Rezoning Transportation Analysis

Petition Number: 2022-224

From: Jake Carpenter, PE

Date	Description
4-26-23	First Review (IW)
11-27-23	Second Review (ME)
11-07-24	Third Review (TM)
11-12-24	Fourth Review (TM)

RZP # 2022-224  
OFFICE AND RETAIL  
CENTRAL AVENUE AND MORNINGSIDE DRIVE  
2609 CENTRAL AVENUE

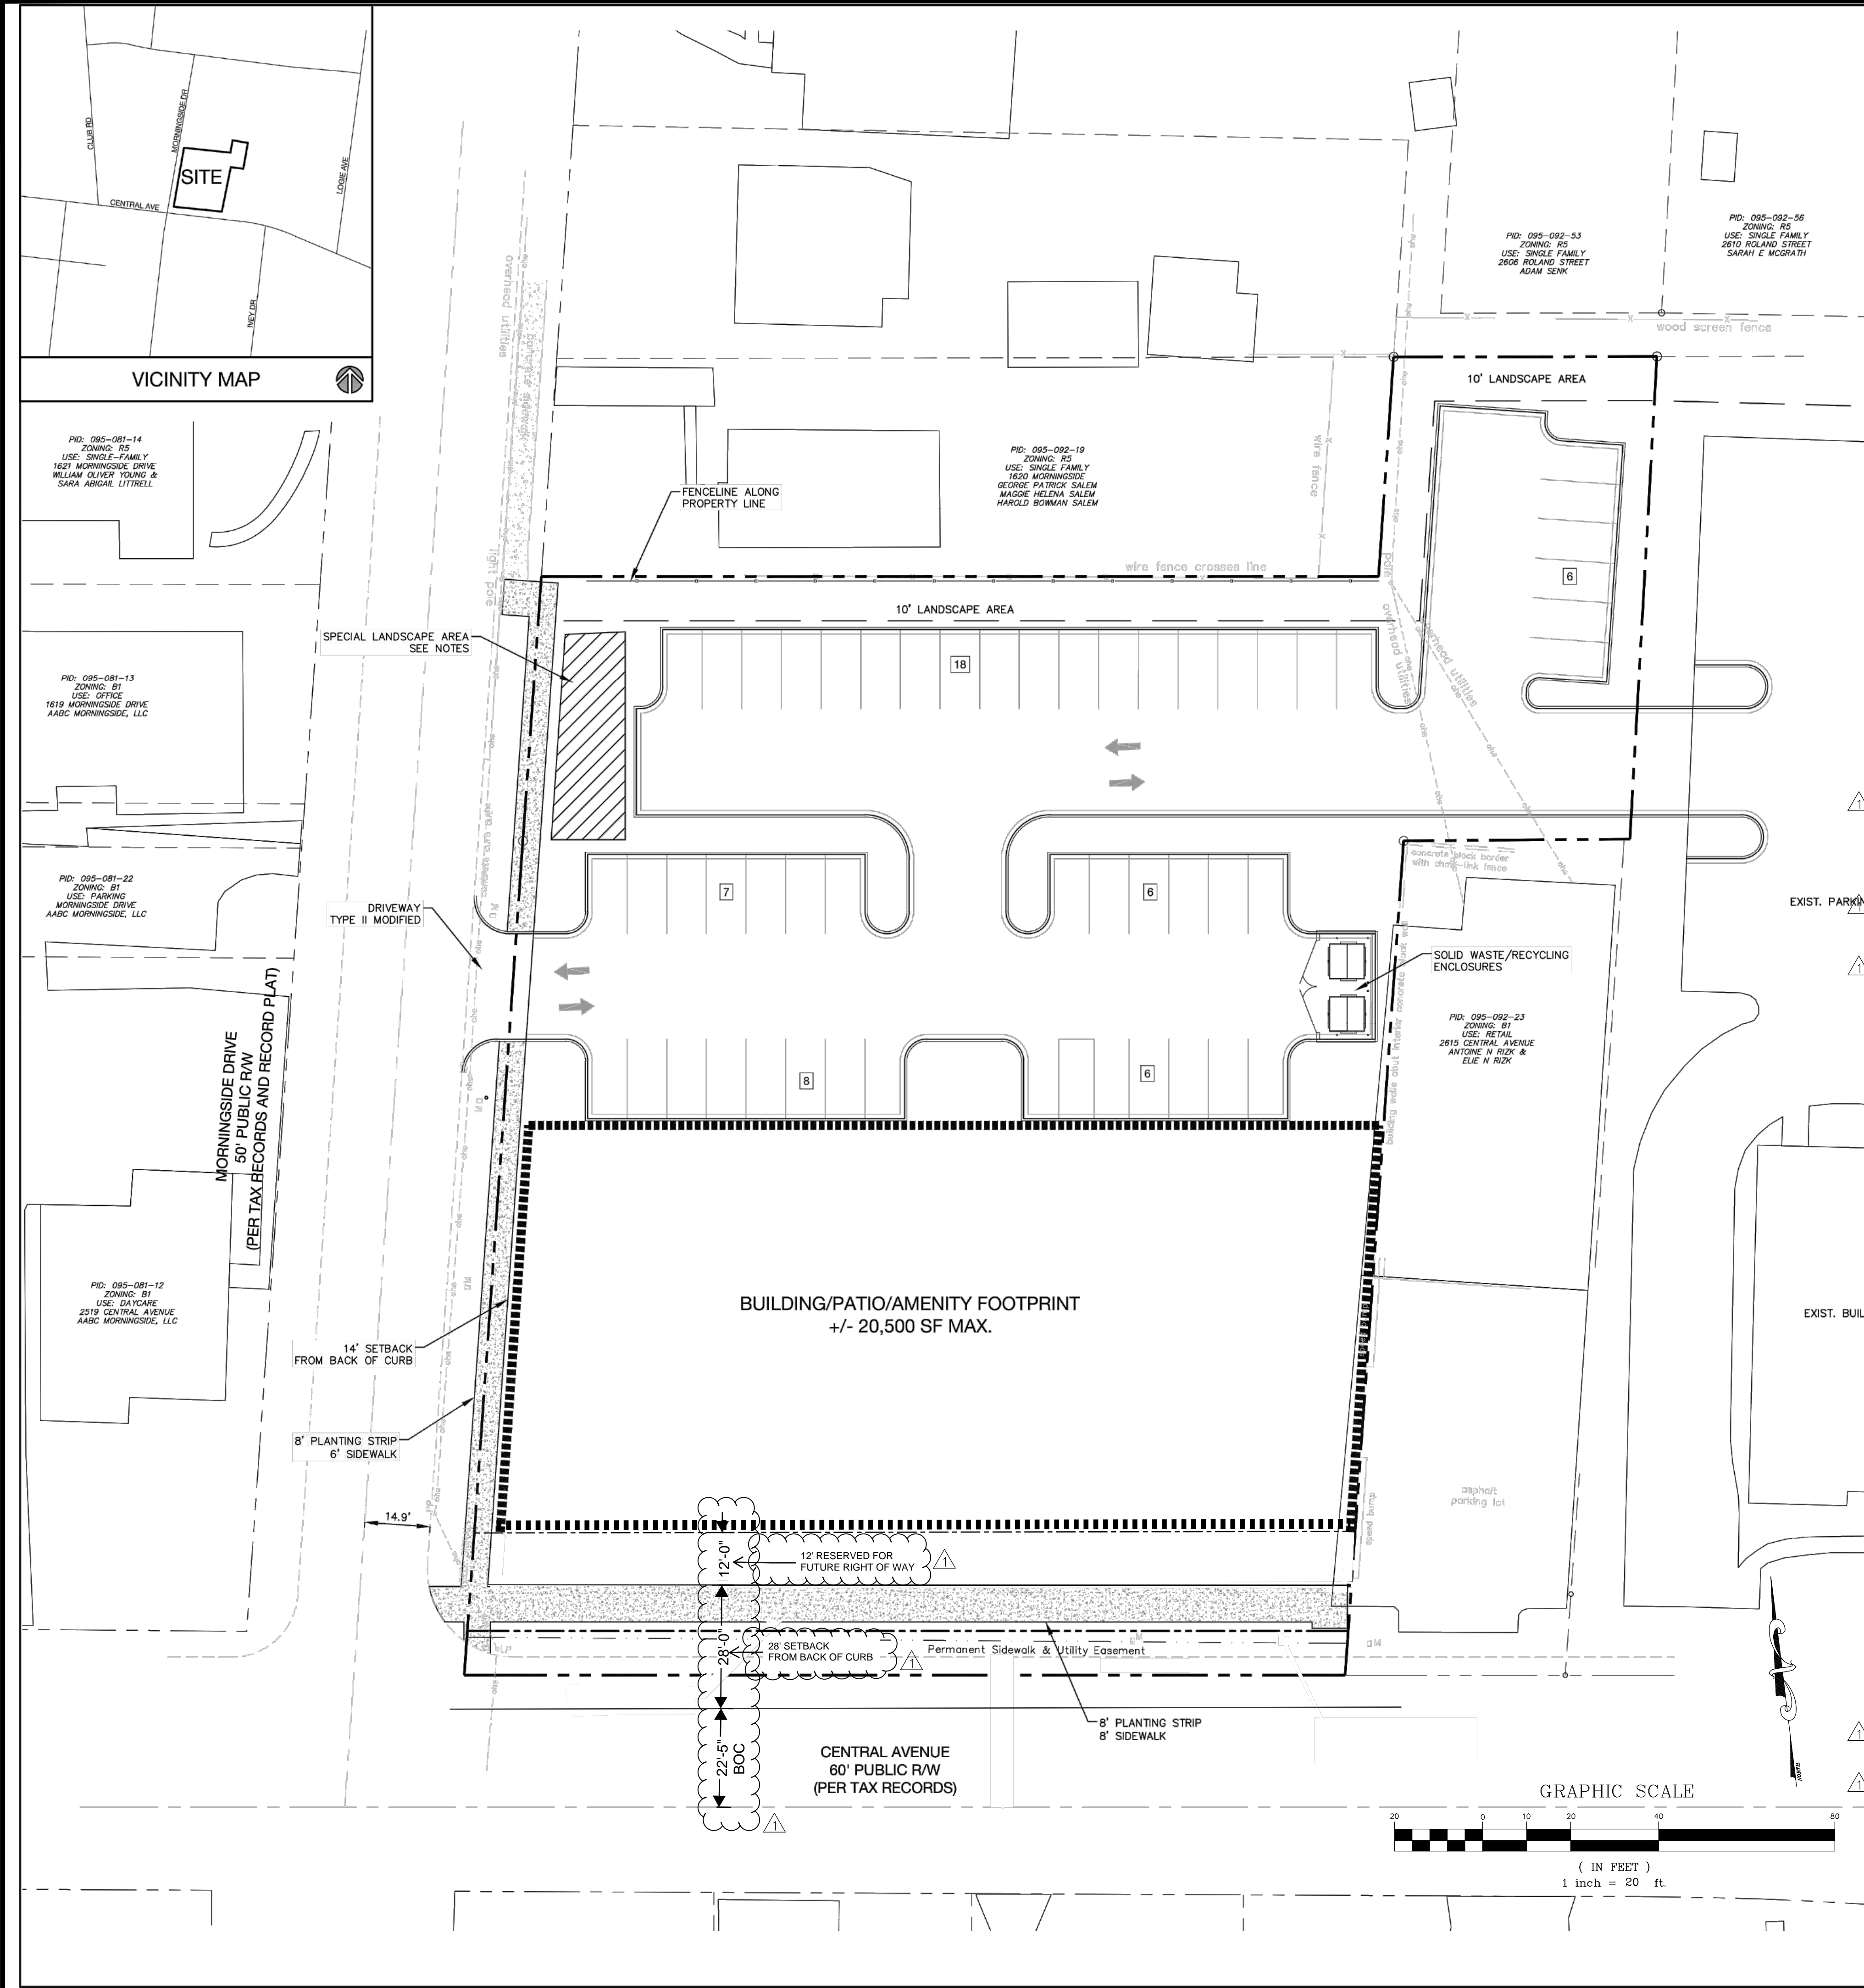
- a. ~~**Central Avenue:** Location of curb and gutter to be moved to 32.5 feet from roadway centerline to accommodate the Charlotte Streets Map with a roadway typical section of 4 Avenue with Buffered/Separated Bike Lanes.~~
- b. ~~**Morningside Drive:** The future location of curb and gutter is in its existing location.~~

~~Label and dimension the curb and gutter from the centerline for each road on the site plan.~~

~~**Comment 11-27-23:** Label and dimension curb and gutter locations not shown on site plan. Please add to the site plan.~~

- ~~3. Revise site plan and conditional note(s) to commit to dedicate 50.5 feet of right-of-way from the Central Avenue road centerline. The site plan shall label and dimension the right-of-way from the road centerline.~~

~~**Comment 11-27-23:** Please add a label and dimension showing right-of-way dimension mentioned above on site plan and revise conditional note(s) to commit to previously mentioned right-of-way dimension.~~

~~**Clarifying comment 11-07-24:** Add dimensions from the roadway centerline to ROW along both frontages.~~
